SLAE Written Representation Submission for Deadline 10 - Sustainable Transport Fund (STF) & Residual Impacts Fund (RIF)

003034-8.119 Sustainable Transport Fund

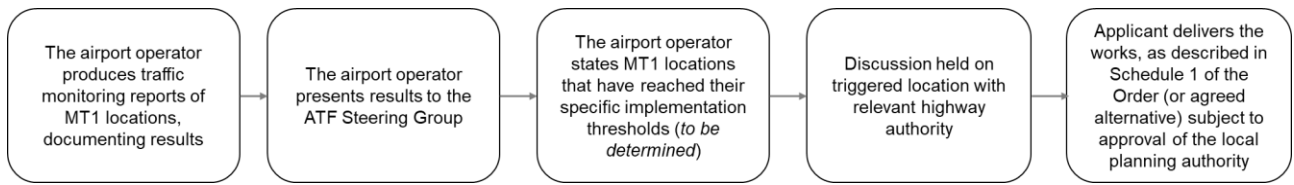
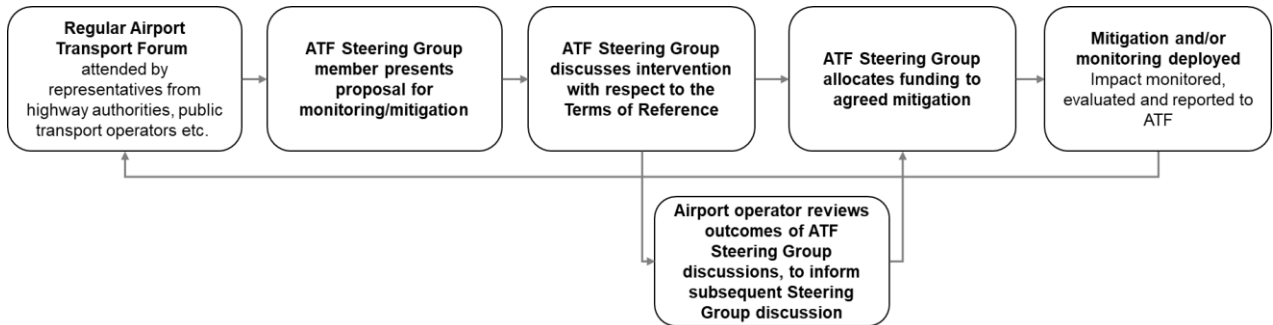
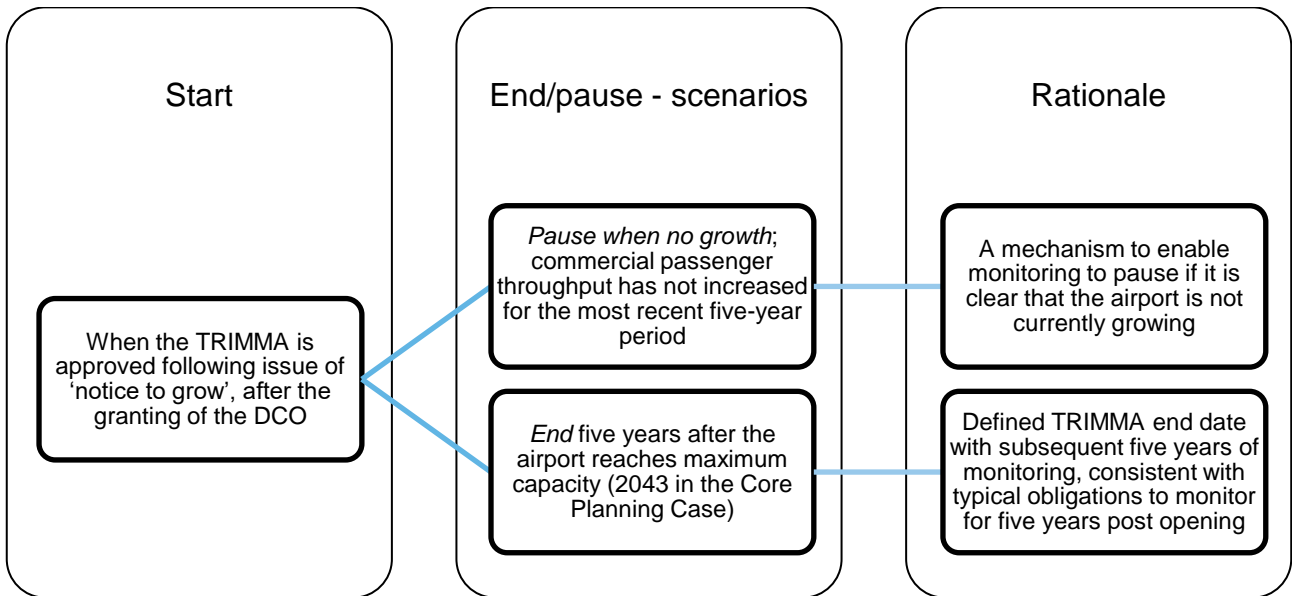
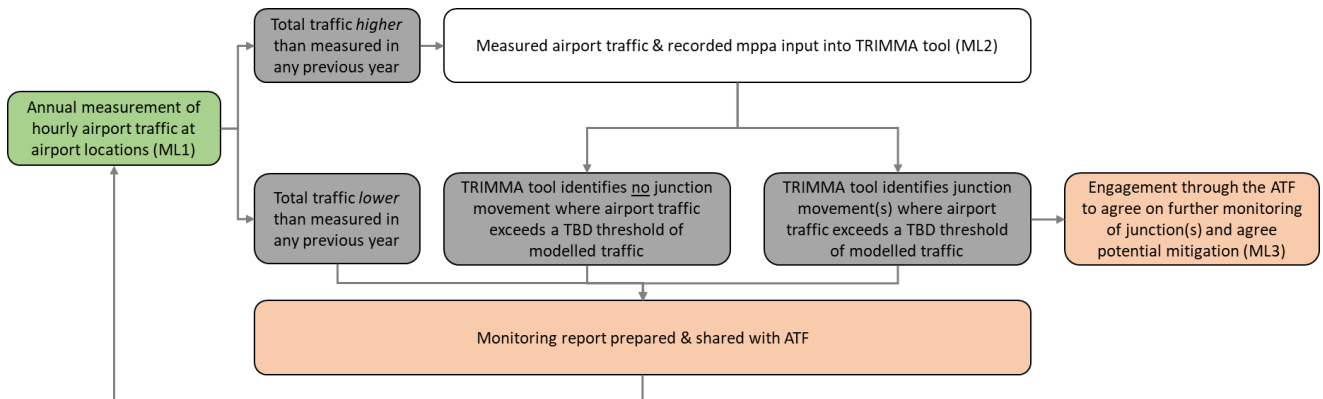
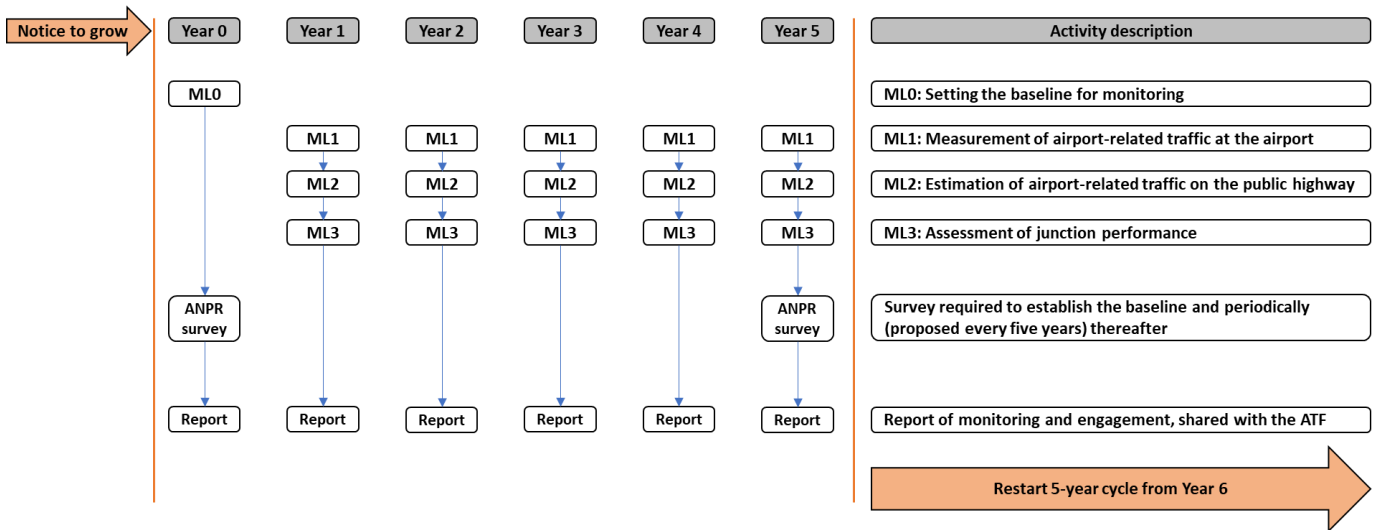
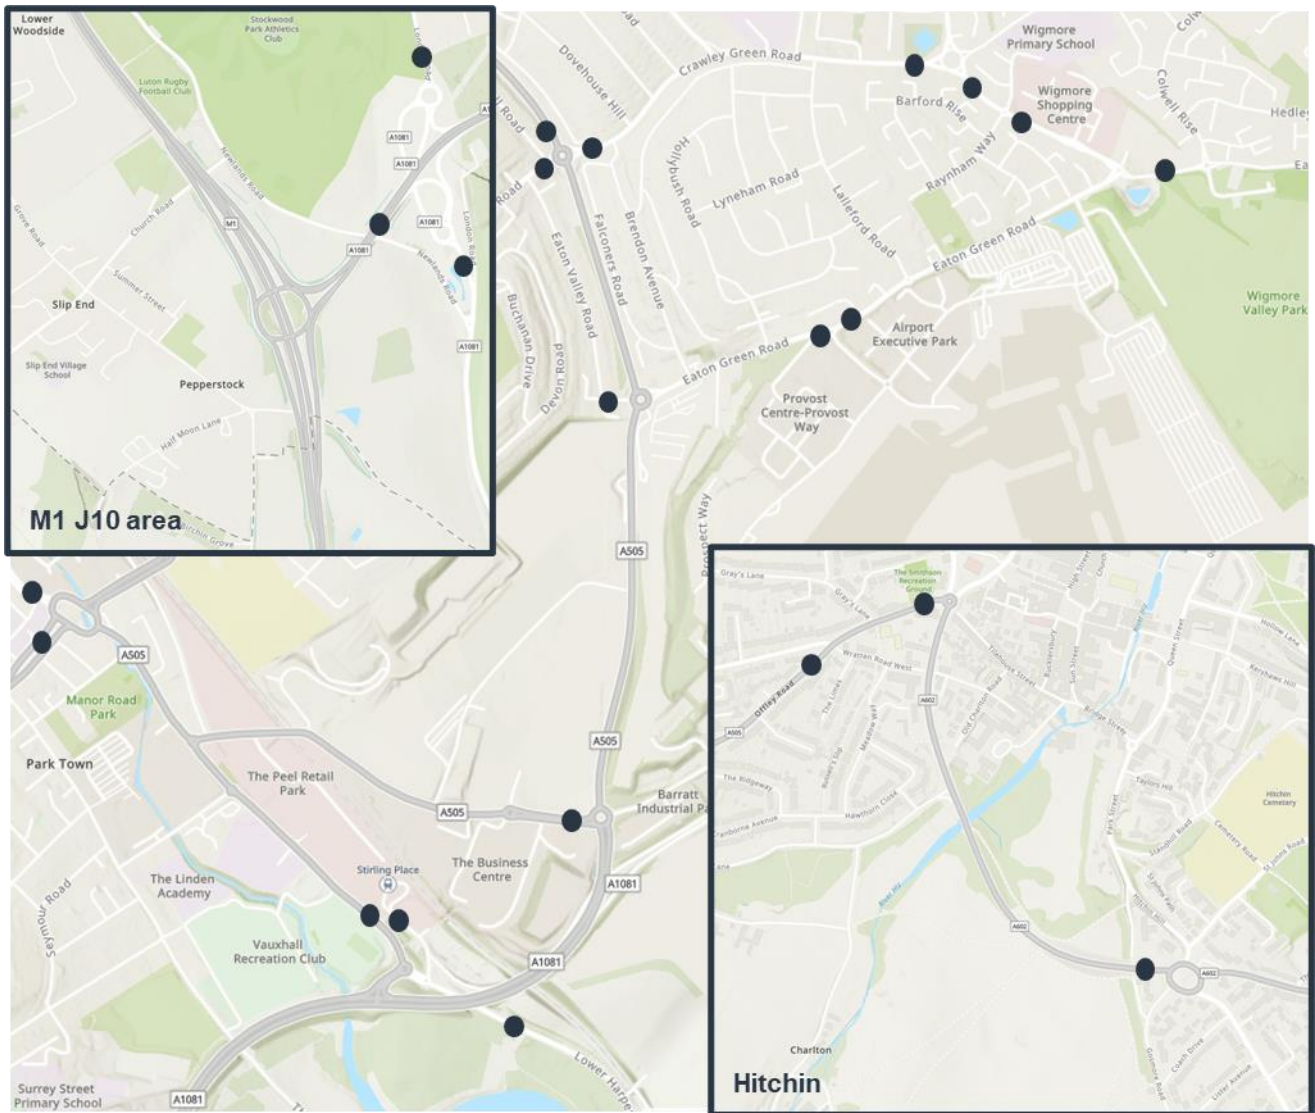
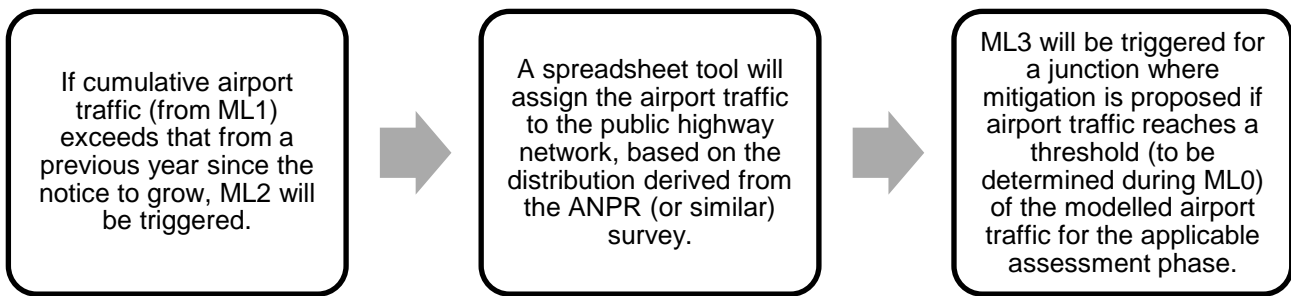
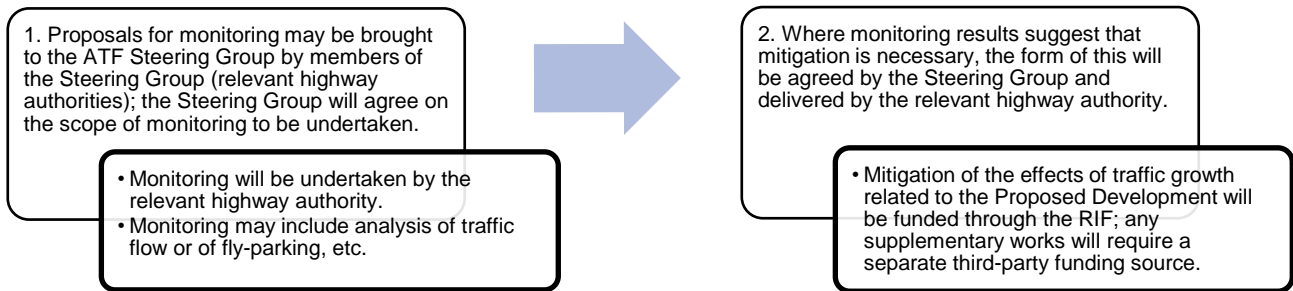
SLAE reflect the concerns that the National Highways reflect in TR020001-002589-8.127 Applicant's Response to Deadline 5 Submissions Appendix E - National Highways, I.D 9. SLAE note that Luton Rising's response is lacking in detail and avoids many of the questions asked.

There needs to be a provision for a fund that exists to deal with residual airport-related traffic impacts for the life of the airport.

002368-8.97 Outline Transport Related Impacts Monitoring and Mitigation Approach (TRIMMA)
4.1.2 The RIF will be a finite fund for the mitigation of residual airport-related traffic impacts. This fund will be secured in the section 106 agreement. Further details will be provided in the Steering Group Terms of Reference to be contained in the final TRIMMA

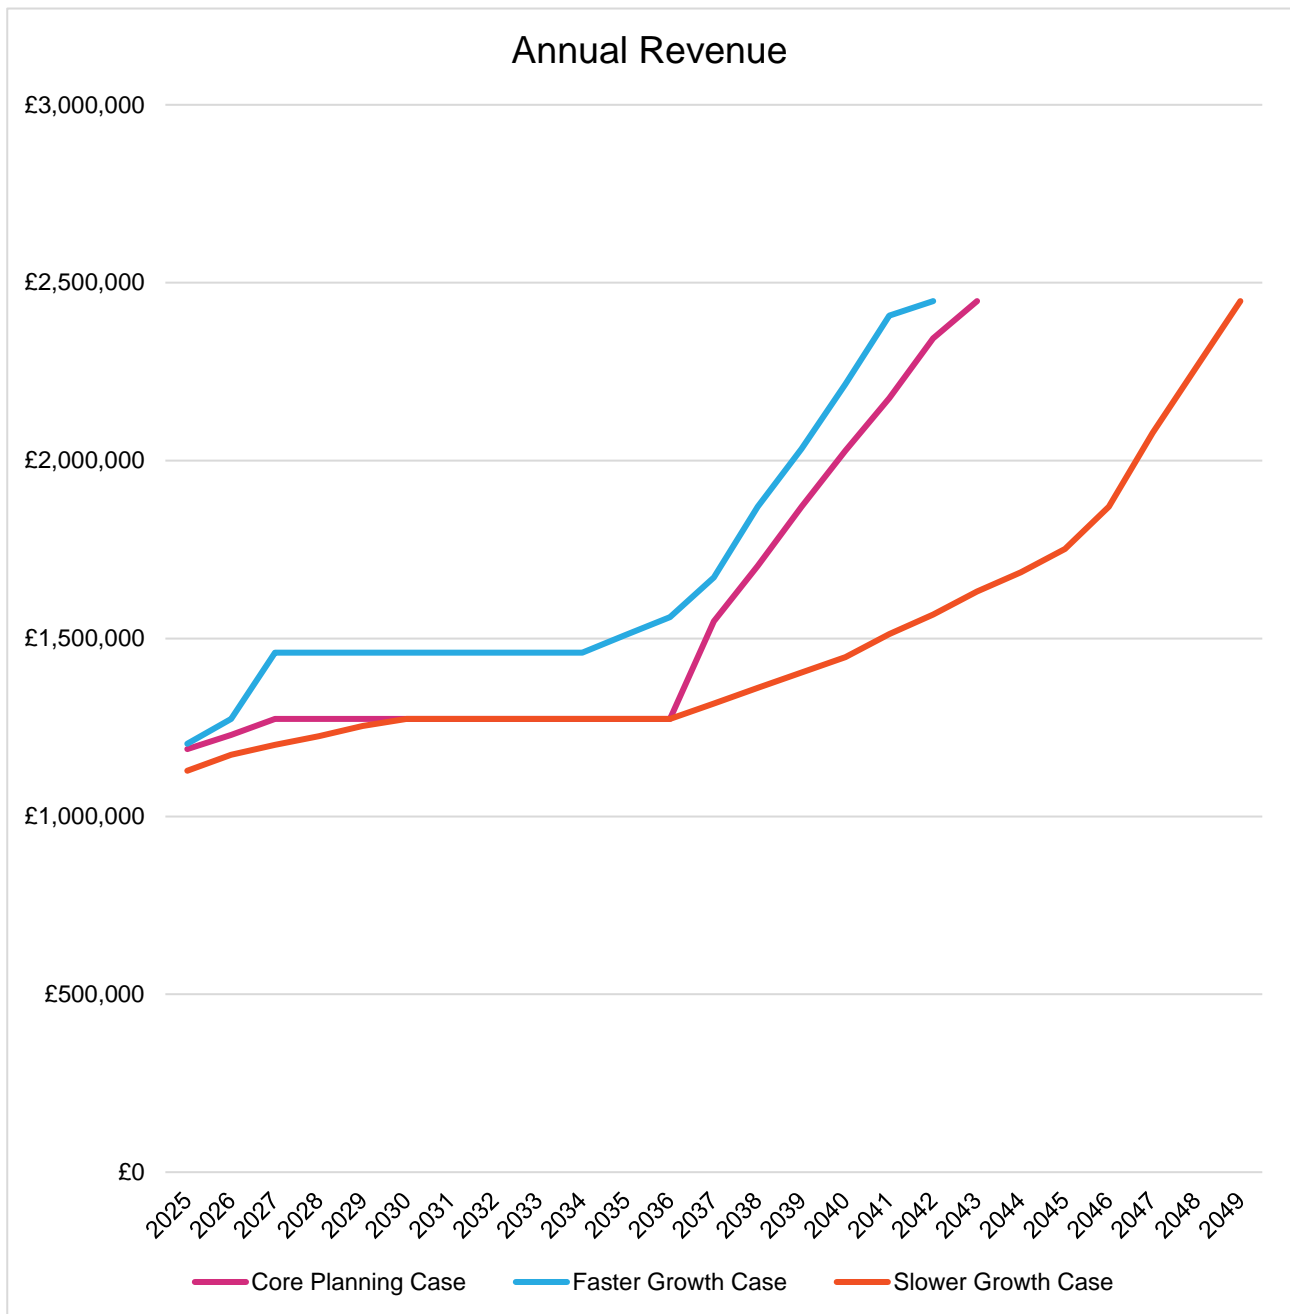
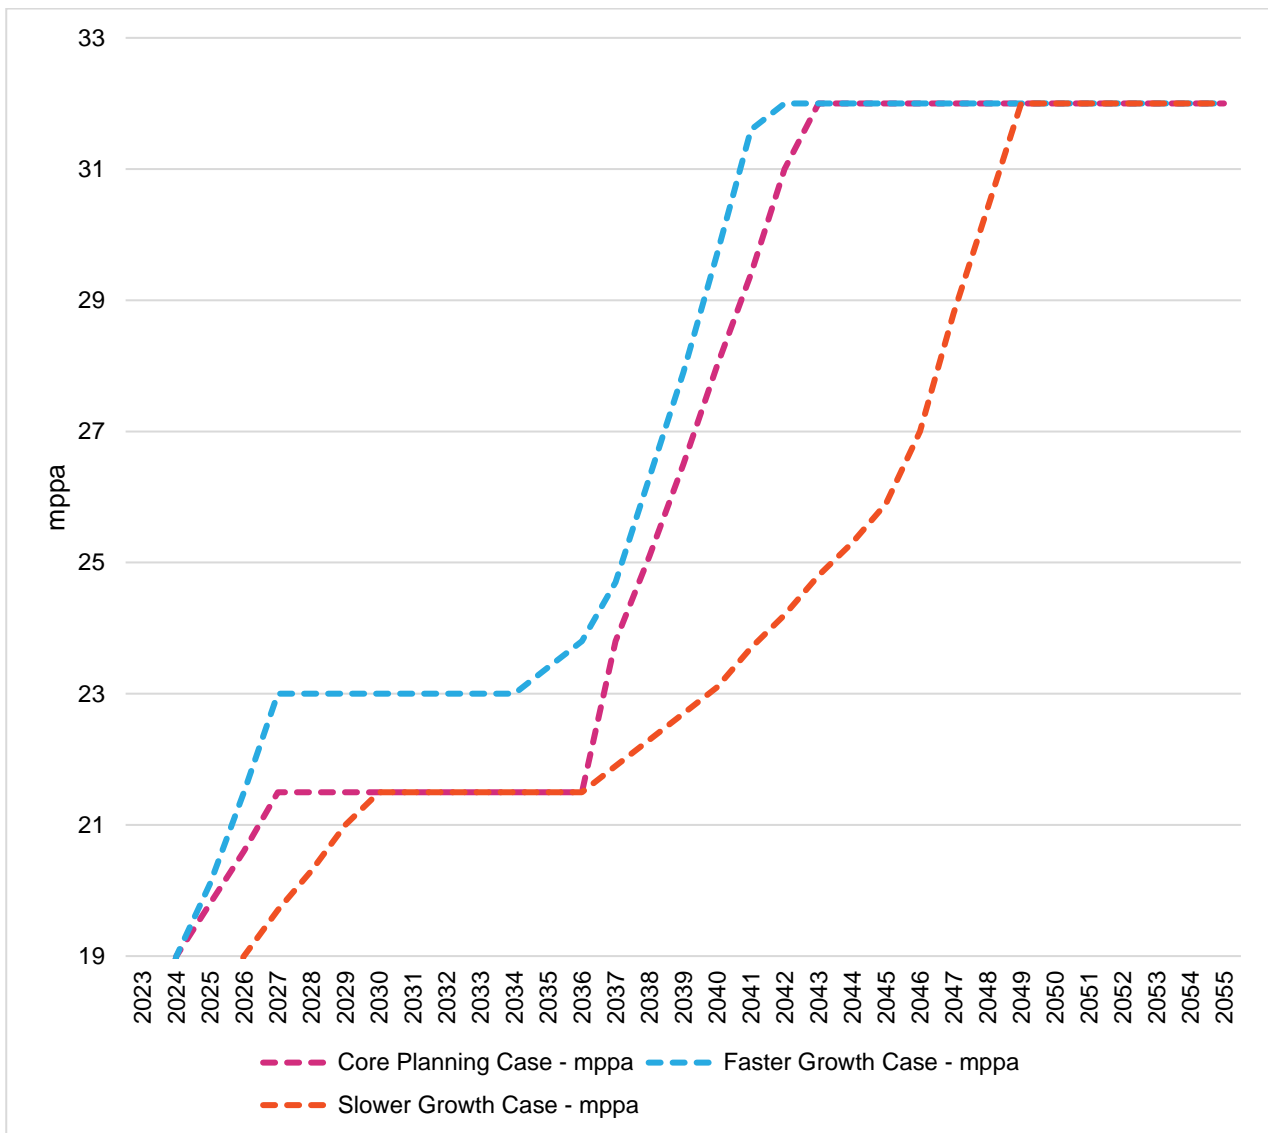
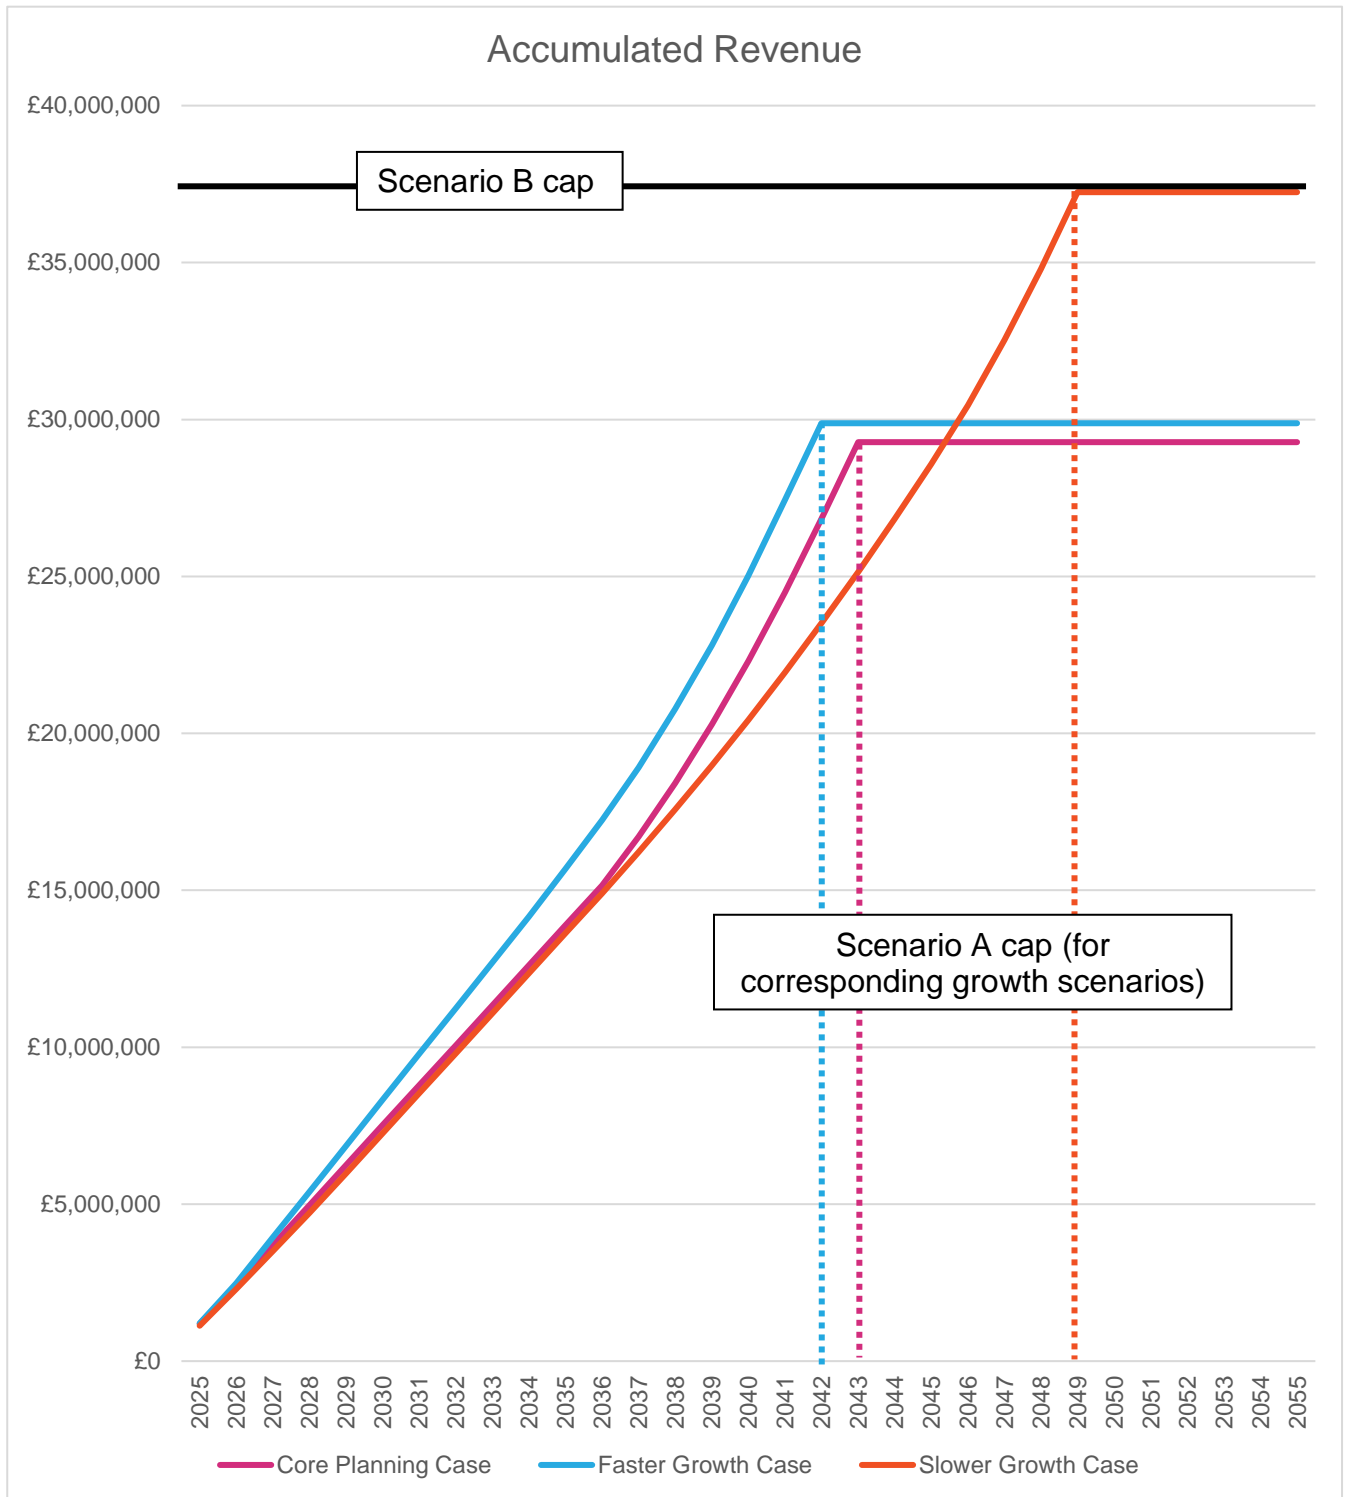
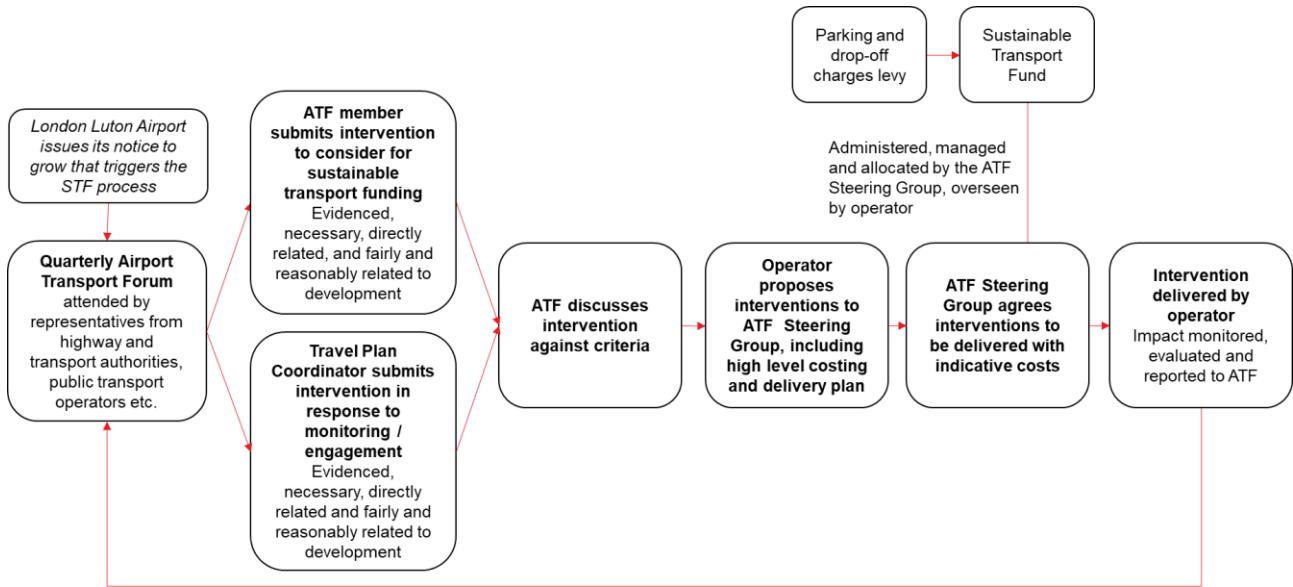
Any charges to staff for parking will encourage fly-parking. Do LR or LLAOL charge staff for parking and if so, what are the charges?

The key word here is 'new' and not new bus routes at the expense of existing bus routes.

Where does the £1,000,000 come from? Is this fund taken from the RIF?
Does this mean that the RIF fund is £1,000,000 and STF is also £1,000,000?

Is the assumption that any Controlled Parking Zone costs are addressed before any surplus is redistributed?

Why is there no representative for residents of airport adjoining wards on the ATF and steering group?

2.2.3 No levy will apply to staff parking, to avoid any potential for fly-parking on roads around the airport, adversely affecting local communities

2.3.12 Feedback from engagement with relevant highway authorities has raised the potential need for the fund to be of a sufficient size in the early years to enable investment opportunities in new bus routes (subject to evidenced proposals and ATF Steering Group approval).

2.3.13 If the first Travel Plan demonstrates a need for early funding, in excess of the initial revenues of the STF being available or sufficient for the purpose, then the Applicant will make available up to £1,000,000 to 'pump-prime' the fund.

2.3.14 If there is any surplus revenue (i.e. any uncommitted funds remaining) at the end of any anniversary of the inception of the STF, up to 25% of this surplus may be redistributed (upon the

recommendation of the ATF Steering Group) to Community First, the Community Fund or the Residual Impacts Fund. Redistribution to the Residual Impacts Fund will be on the condition that the RIF has been exhausted at the time of redistribution.

2.3.15 If there is a surplus upon any anniversary following the throughput of passengers at the airport exceeding 31.5 mppa, the ATF Steering Group may recommend to the operator that levies be reduced or removed as appropriate. Proposed ATF and ATF Steering Group membership (one representative from each body)
